Planning Application Decision Notice

REFUSAL OF PERMISSION FOR DEVELOPMENT

Application Number: 2024/62/90389/W

**ERECTION OF STAIRCASE TO FRONT ELEVATION WITH REPLACEMENT
PORCH ROOF AND ALTERATIONS (RETROSPECTIVE)**

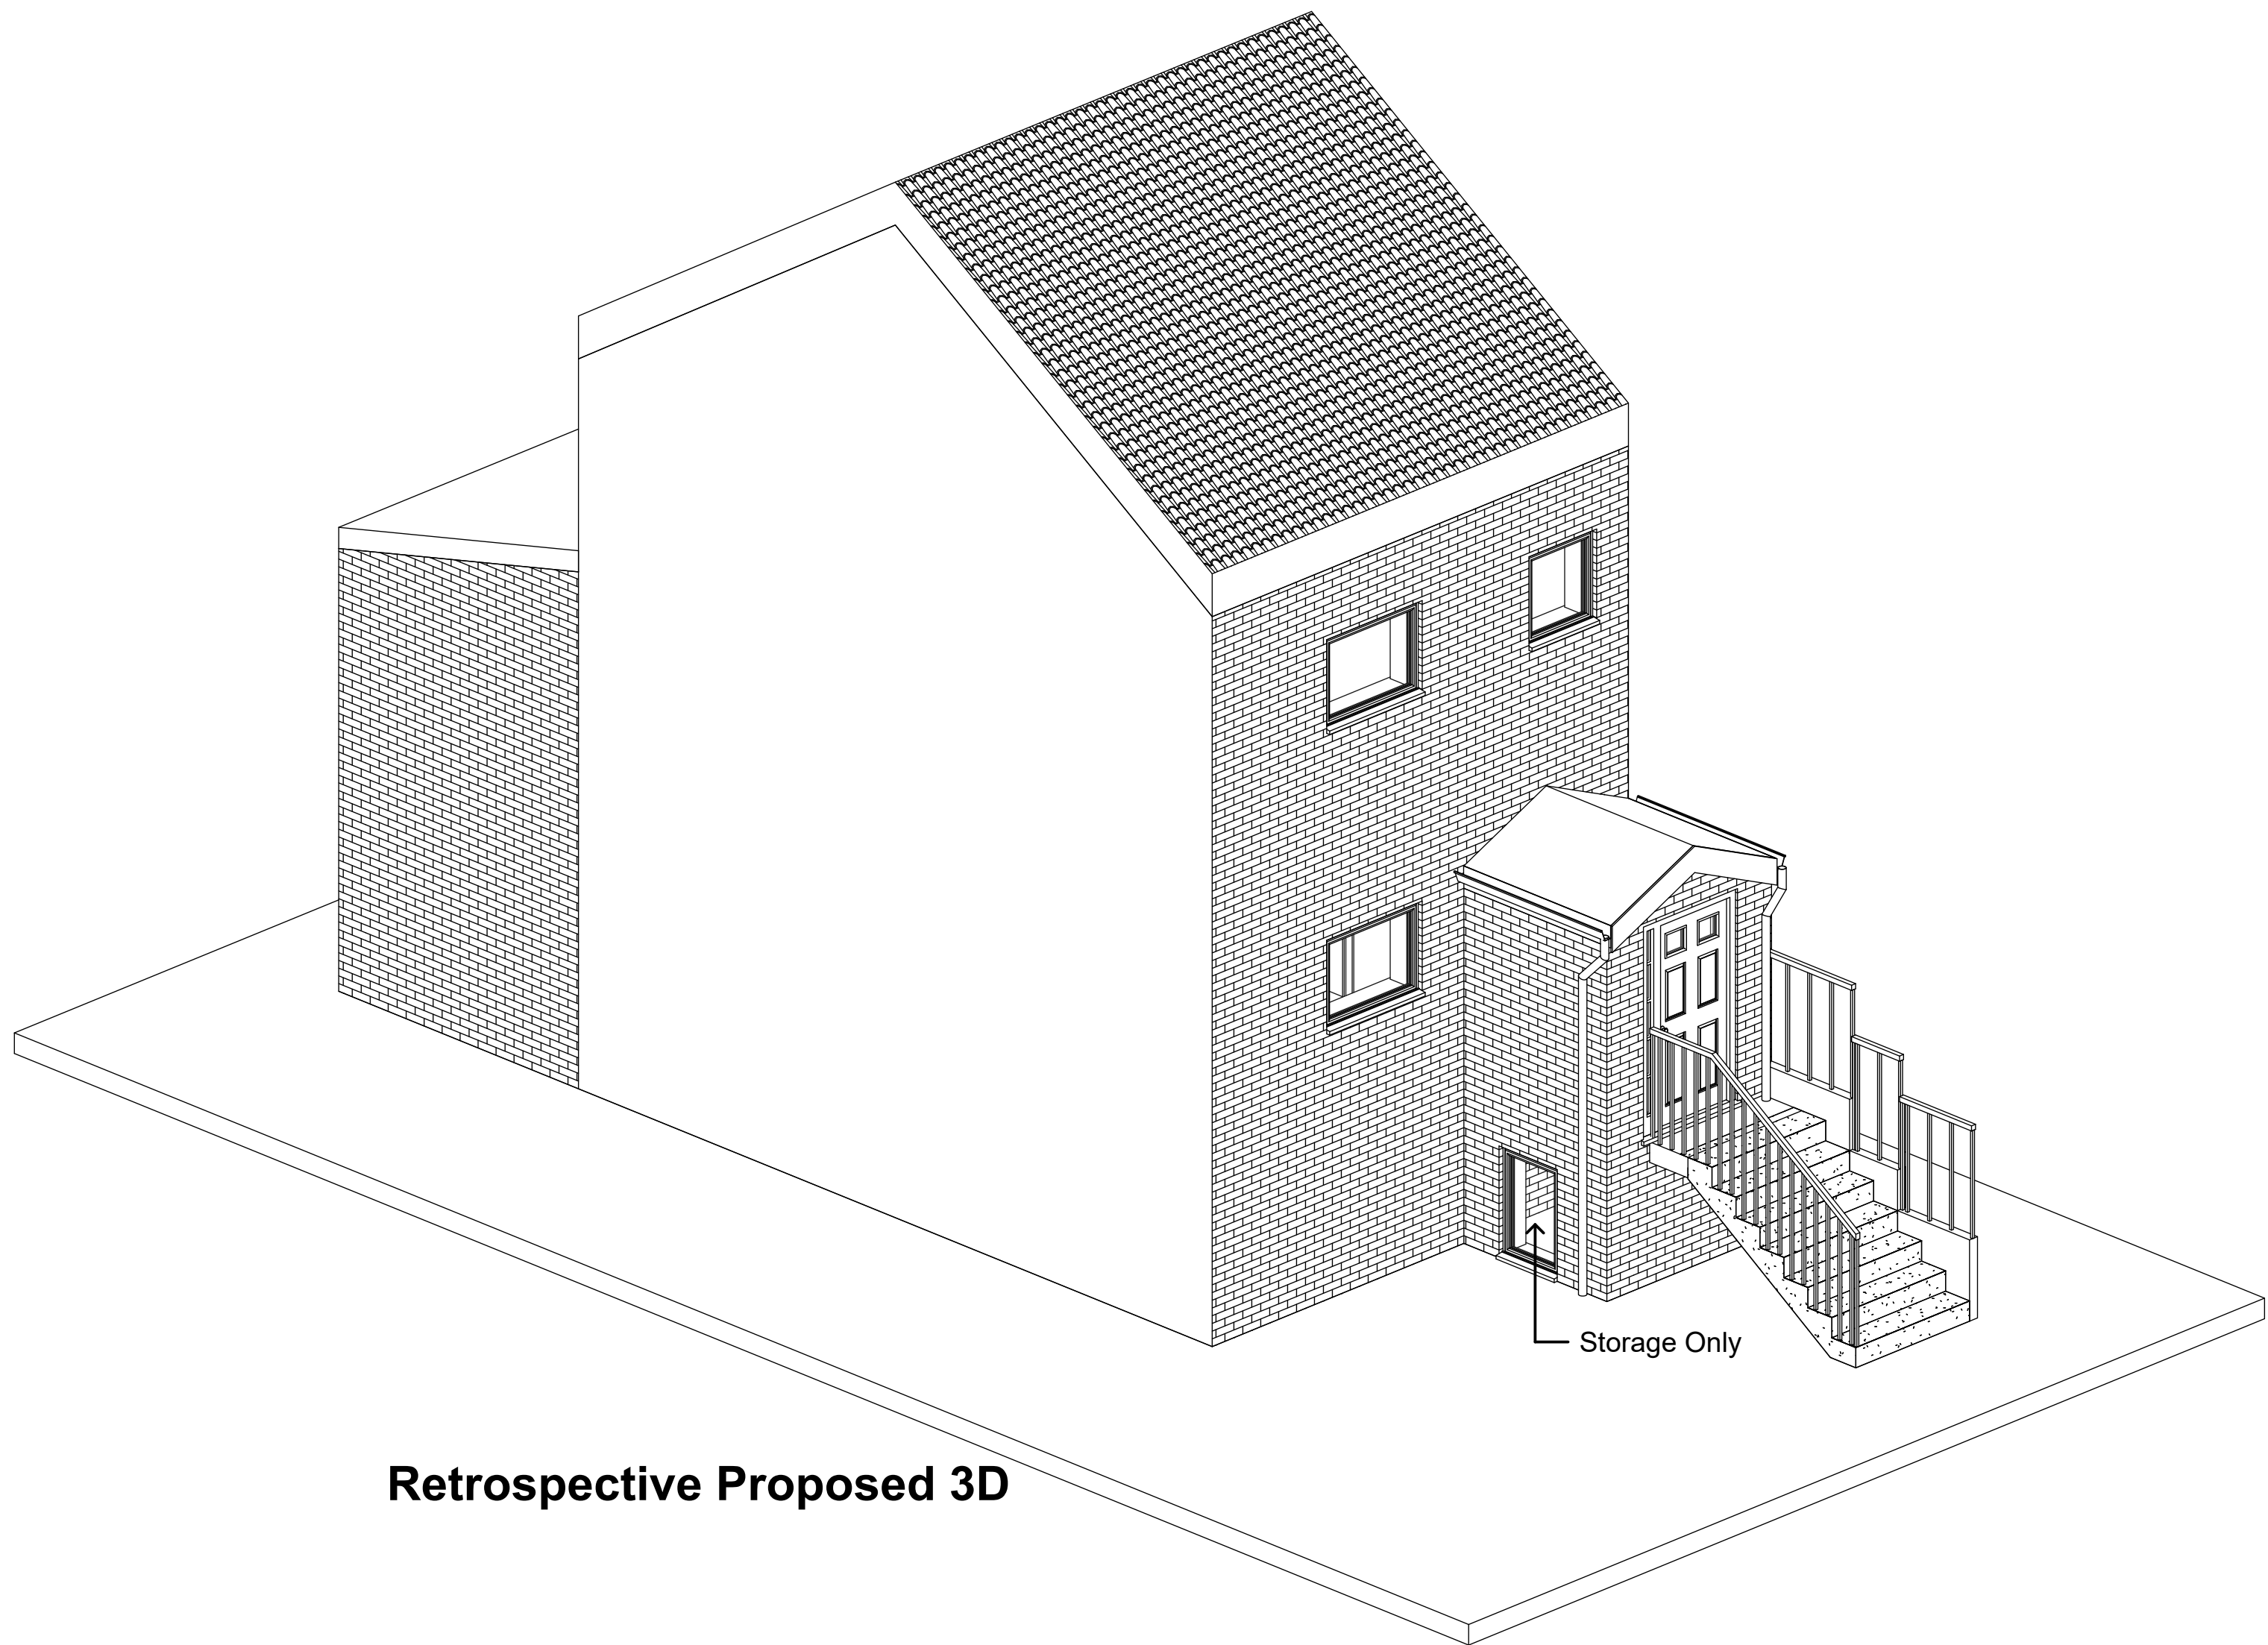
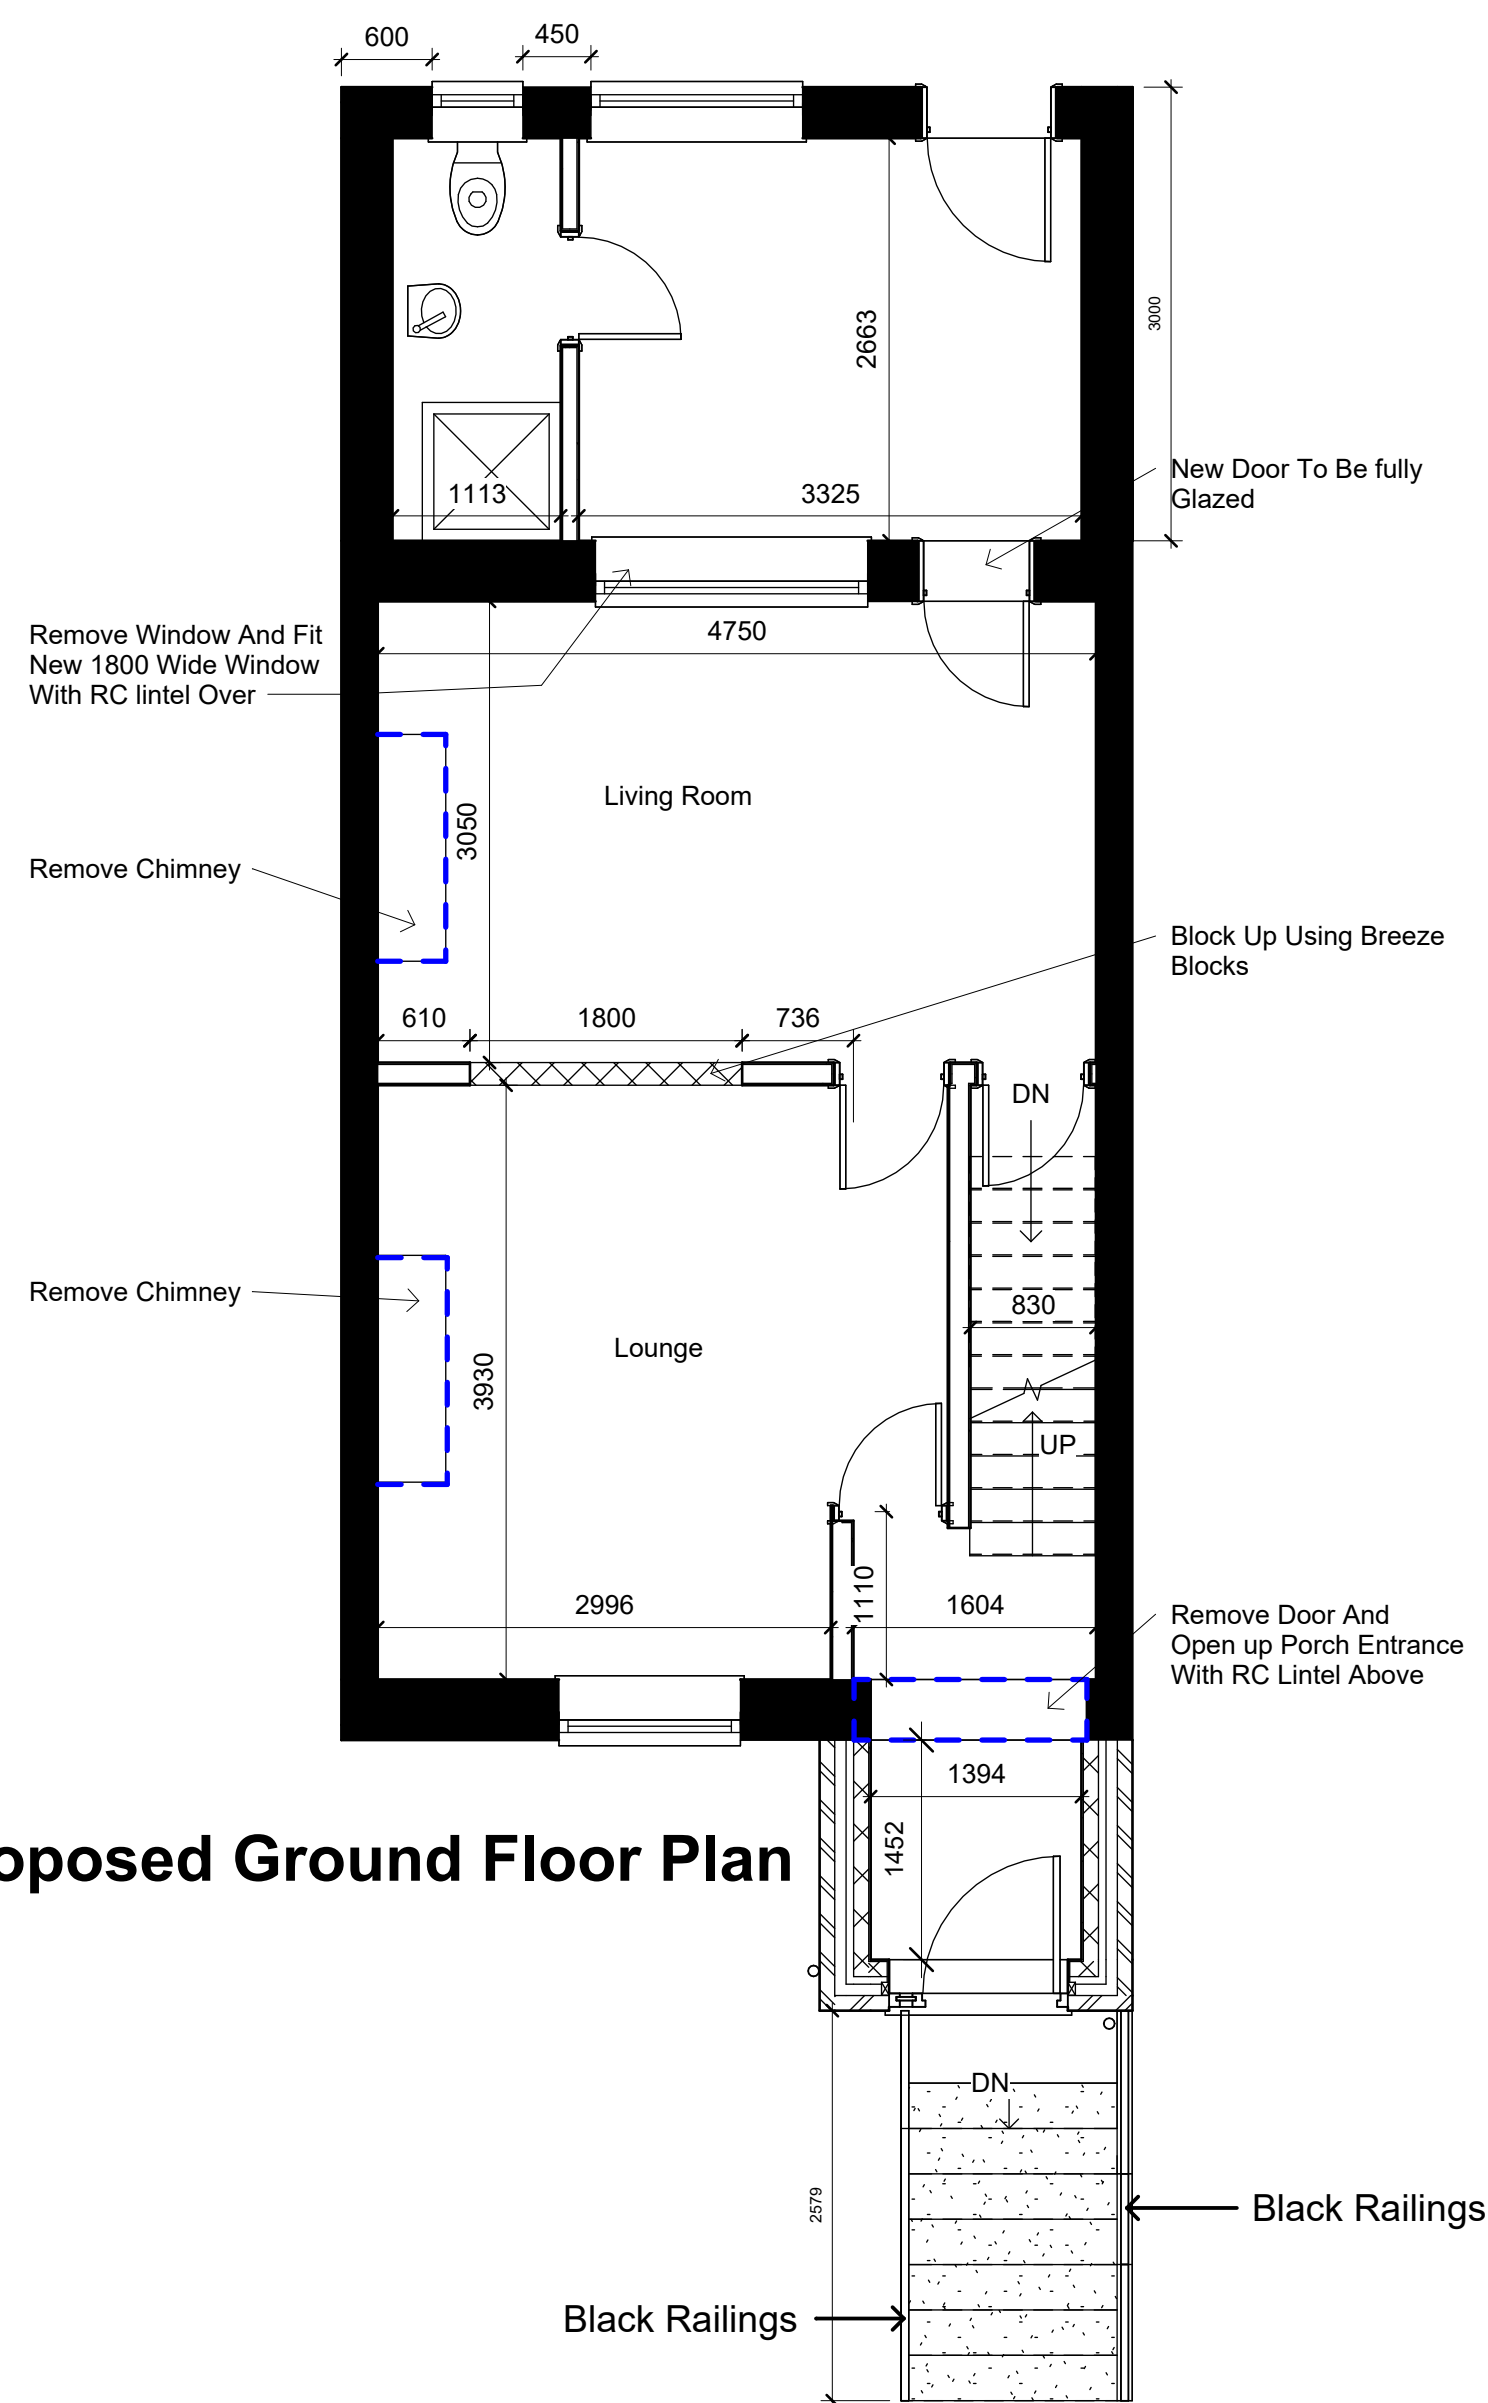
No negotiations have taken place with the applicant/agent due to the application being submitted retrospectively. Clarification was sought from the Agent as it was noted on site that there was a side elevation opening within the staircase. The Agent confirmed that the window was only to allow light into the storage area. Updated plans demonstrating the opening were subsequently received.
